# **M54 to M6 Link Road**

## **TR010054**

### **8.15 Applicant Responses to Documents Received at Deadlines 1 and 2**

November 2020

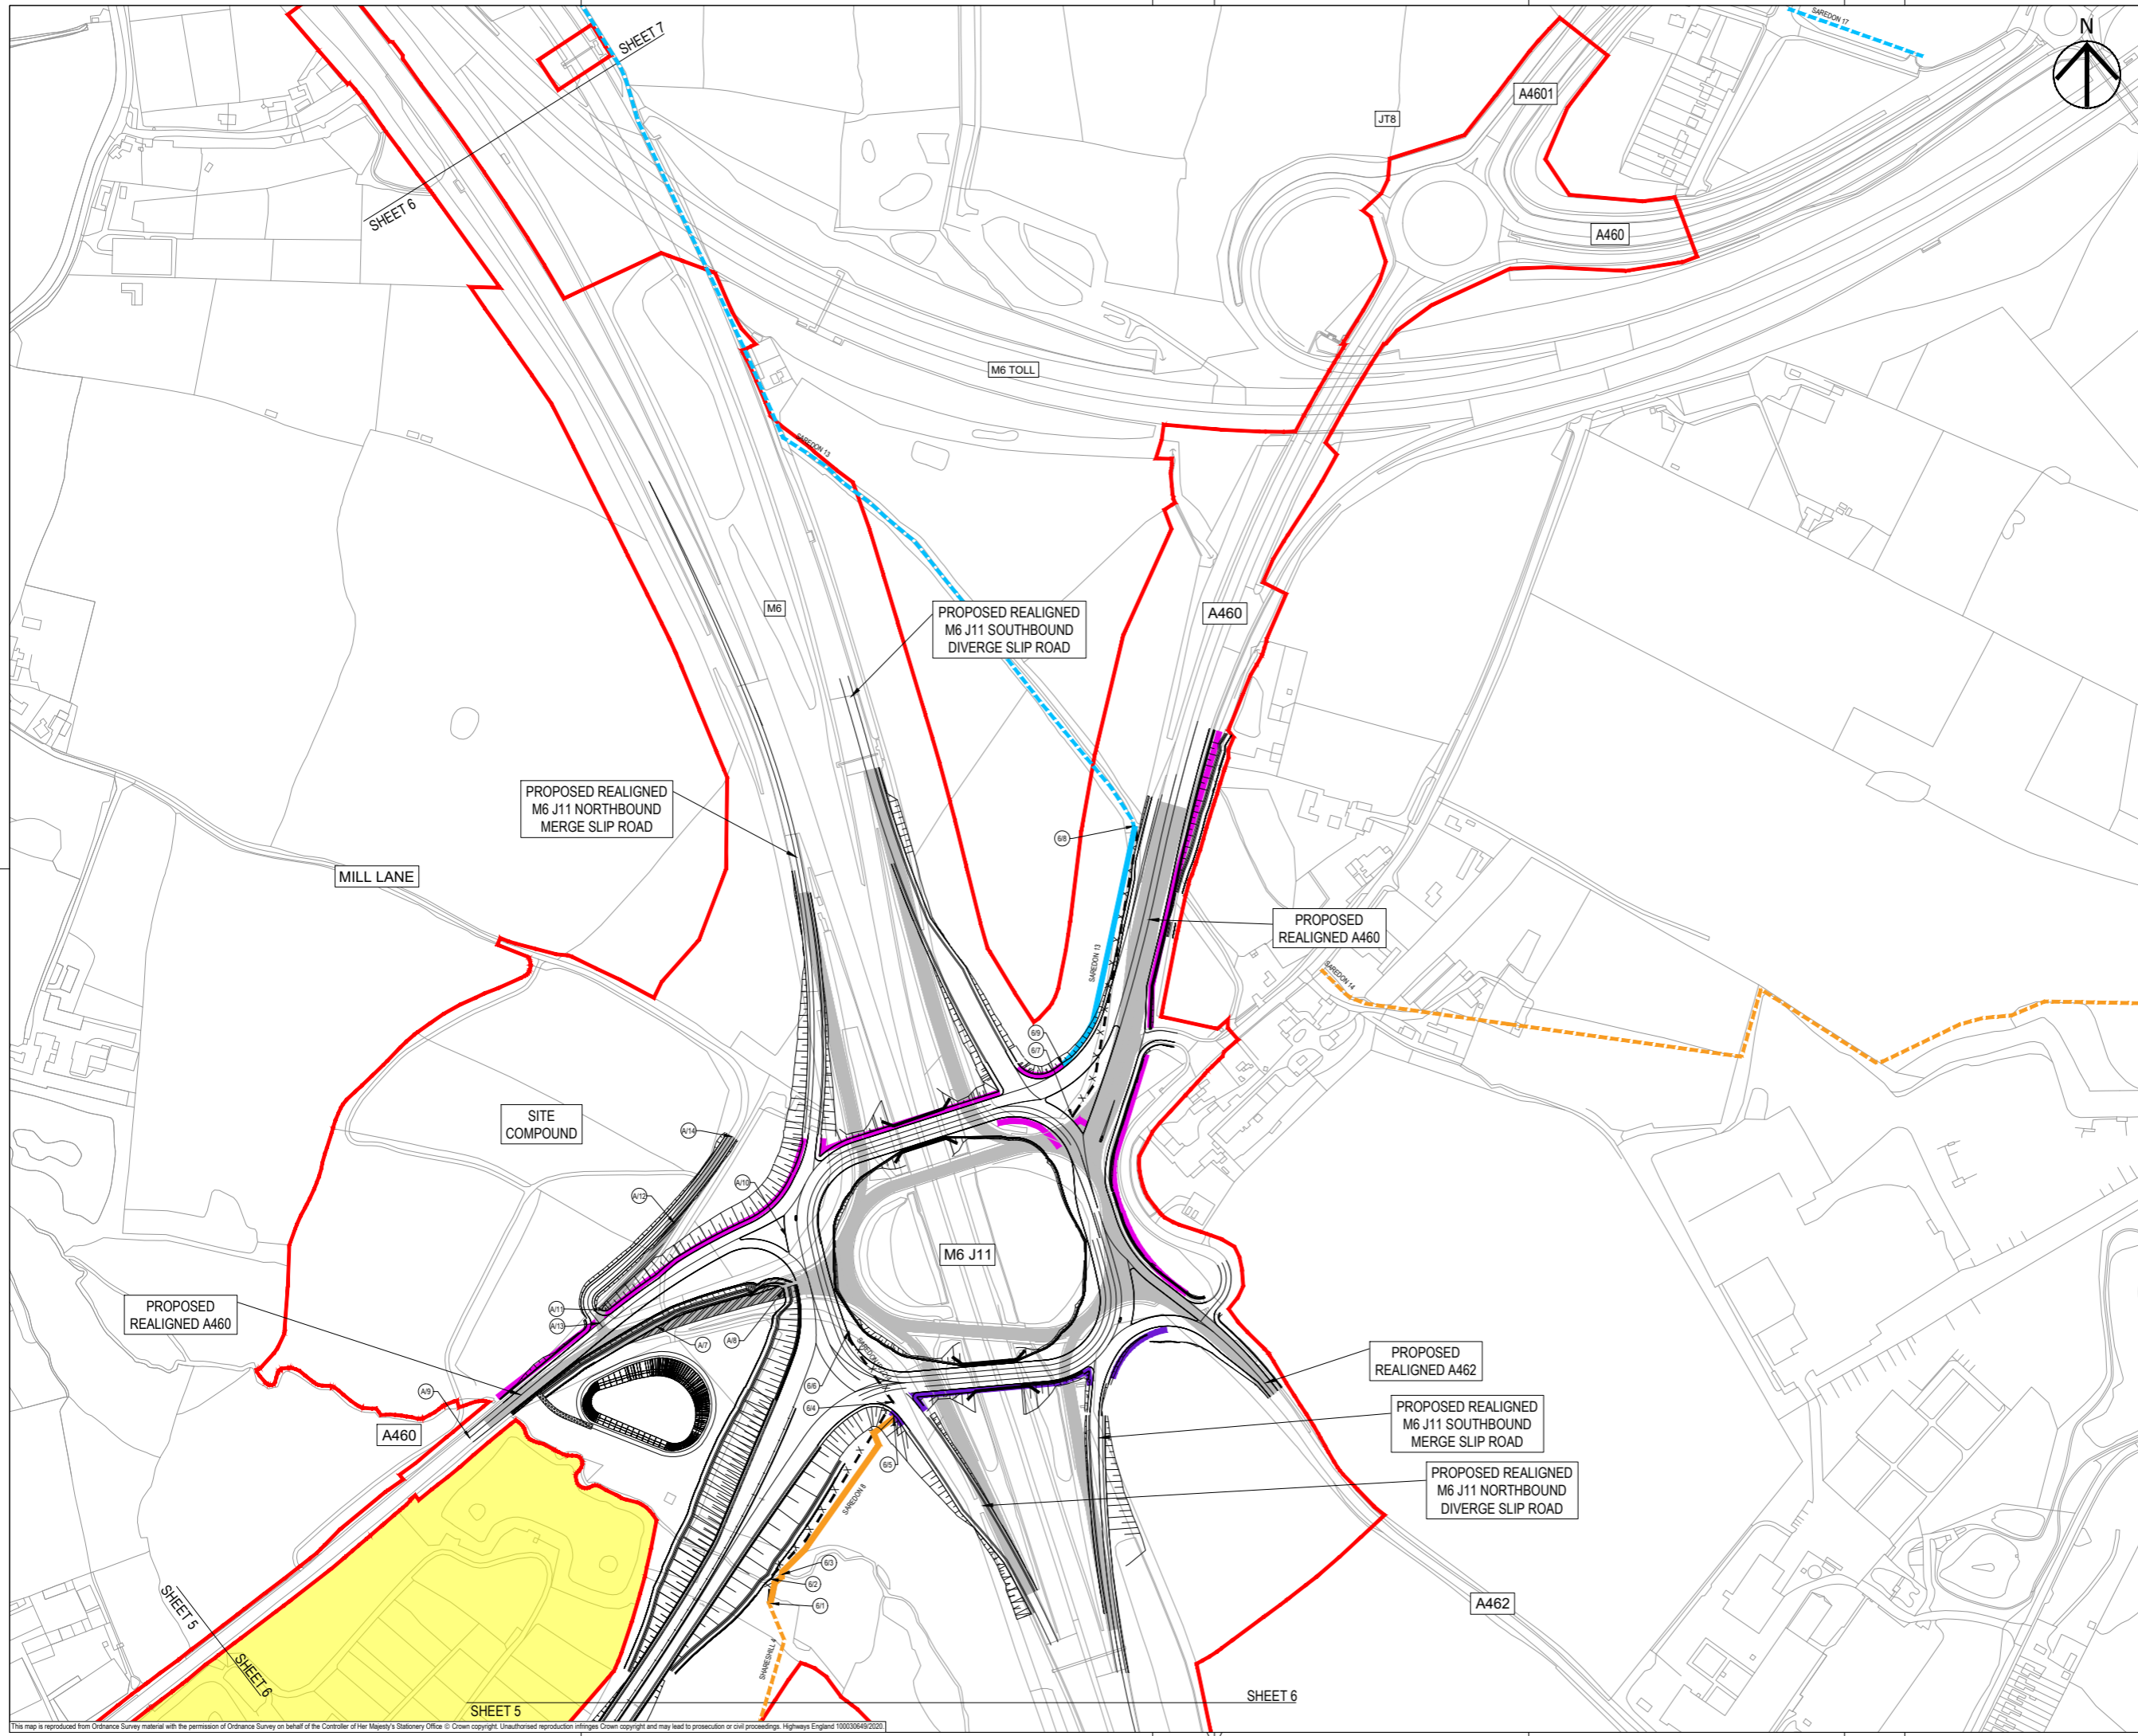
Issue 8a: page 4 para 5 & 6	<p><b>Parking at the southern end of the old A460</b> As a result of the realignment of the old A460 there are areas of the original route that are proposed to be stopped up or the carriageway removed as indicated on STREETS, RIGHTS OF WAY AND ACCESS PLANS REGULATION 5(2)(K) SHEET 4 OF 10. There are two issues here that require further work from HE: 1. Southern section In relation to the southern section of the original alignment that is proposed to become a cul-de-sac as shown on the extract below. There are concerns that given its proximity to the strategic road network this area may become subject to indiscriminate parking. Further measures are considered to be required here to ensure its use is only for residential access and highways maintenance activities.</p>	This item has been discussed further with SCC. The turning head proposed at the end of the cul-de-sac is not designed to accommodate for the turning of HGVs therefore it is anticipated that the likelihood of HGV parking in this area is low as vehicles would be unable to exit without reversing. Furthermore, to discourage 'fly parking' it is anticipated that the existing no waiting restriction will be reinstated along this section of the A460 post completion of the Scheme. Further discussion will be held with the local residents and parish council to address concerns regarding parking at this location and the preferable design solution.
